ADDENDA #1 to documents and Specifications dated May 26, 2006.

PROJECT IDENTIFICATION: Customhouse Square Office Building, 300 Fore Street

A. 6' x 12' Sidewalk Transformer Vault (905A-18)

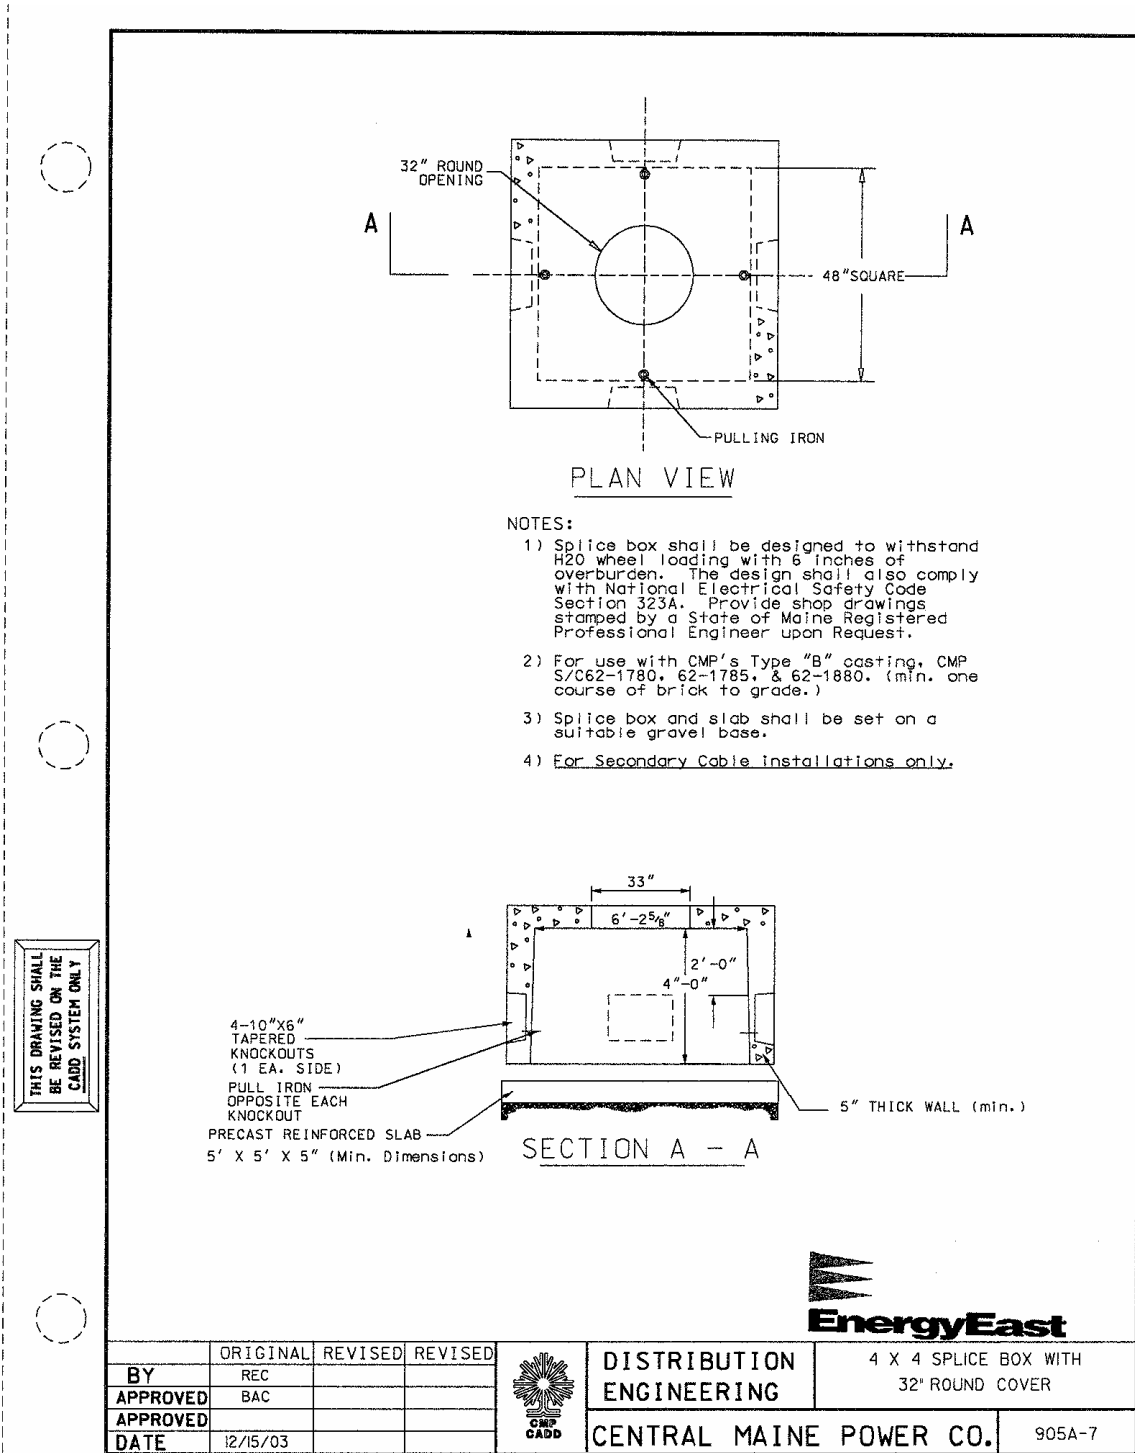
18. Section 02584:
- a. There is a conflict between the CMP details in the spec and the DeLuca-Hoffman details on the civil plans. Are the hatches for the 38Y vaults set into the top of the structure or are

they built up to grade on risers? Setting the hatch into the slab top would expose the entire concrete structure top within the brick sidewalk.

- b. The 38Y structure with the Bilco hatches will not meet an H20 load specification. The typical 38Y has a 30-inch hole for access. Using the hatches will require an engineered structure that will be much larger.

ANS: CMP is reviewing final design issues and will respond at a later date.

ANS: CMP is reviewing final design issues and will respond at a later date.
